Our Ref: 2013/127266-01
Your Ref: MP10_0036 MOD2

RE Modification Request for Chris O'Brien Lifehouse at Royal Prince Alfred Hospital, Camperdown

The application seeks approval for the installation of three double sided, external wayfinding signage structures at the Chris O'Brien Lifehouse at Royal Prince Alfred Hospital.

# Lifehouse External Markers – Final Graphic Layout

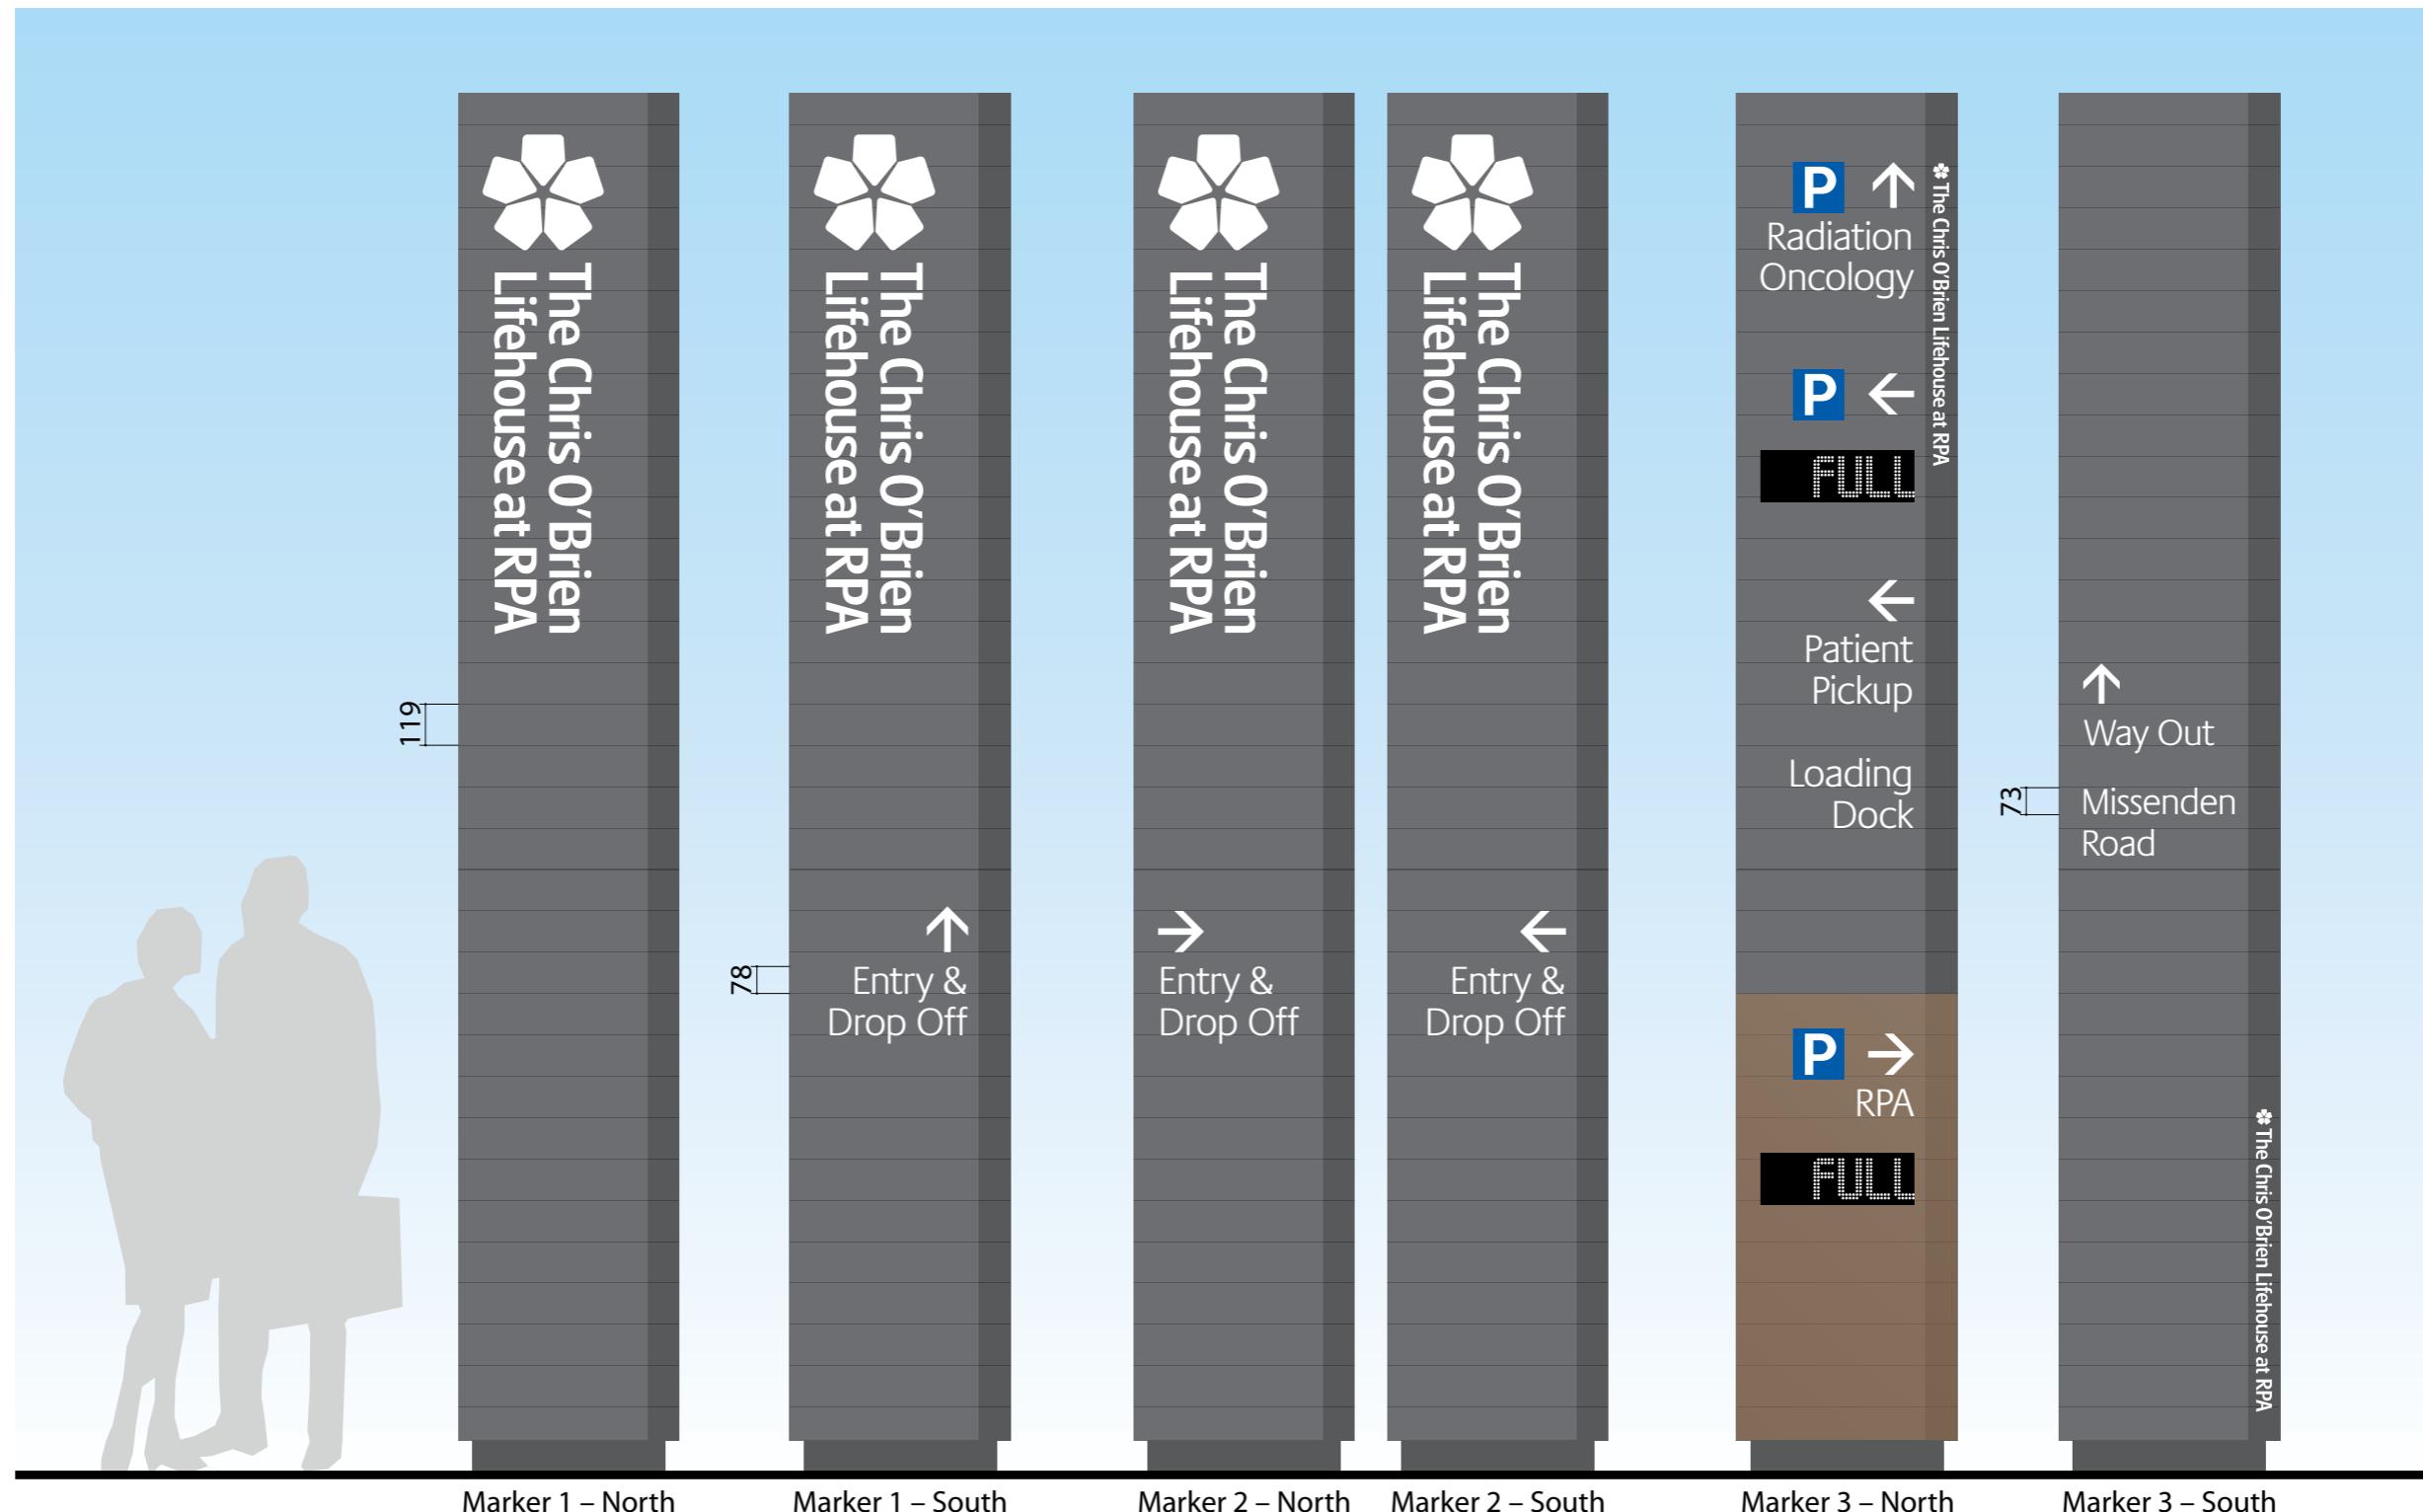
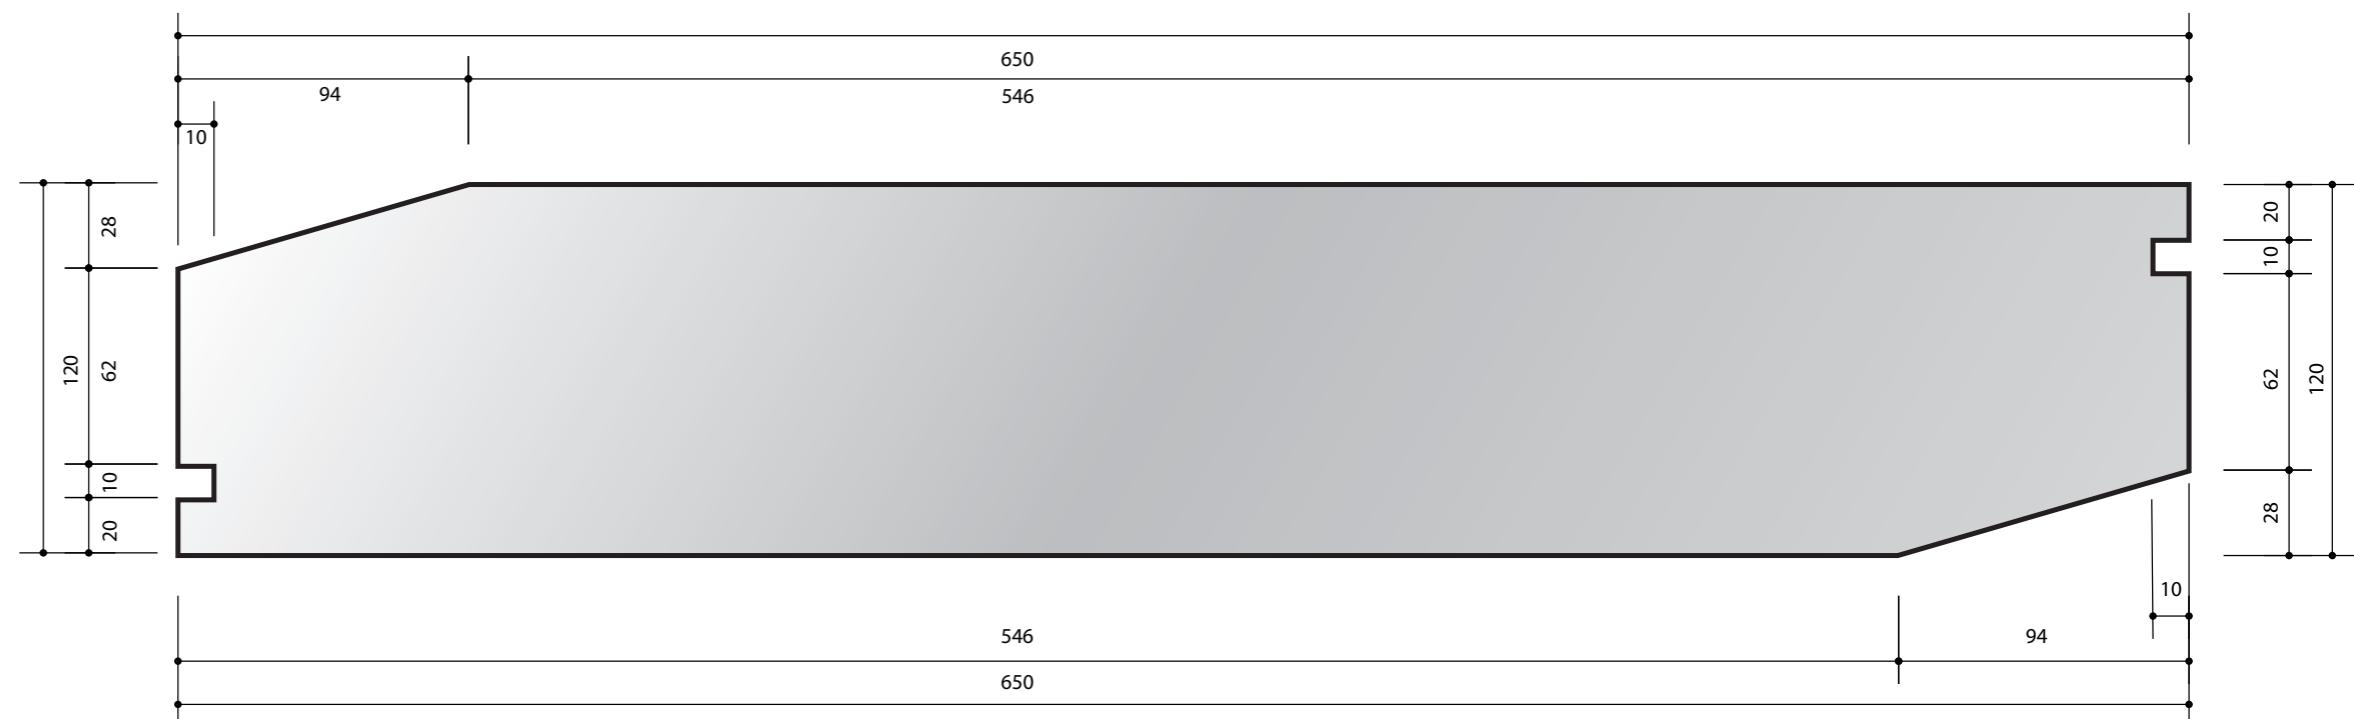
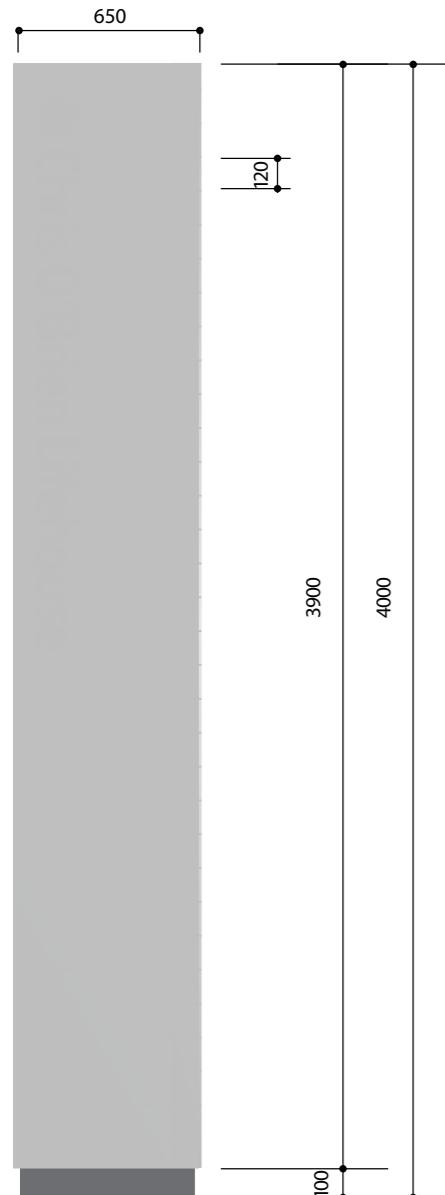
Whilst the City raises no objection to the location and design of the proposed signage, it is recommended that the signage be reduced in height to at least 3 metres to lessen the visual impact of the structures. The following additional conditions are recommended:

(a) At no time is the intensity, period of intermittency and hours of illumination of the sign to cause objectionable glare or injury to the amenity of the neighbourhood and as such must be designed, installed and used in accordance with AS4282-1997 control of obtrusive effects of outdoor lighting.

(b) The sign(s) must not flash.

No portion of the proposed signage structures shall encroach upon Council's footpath area.
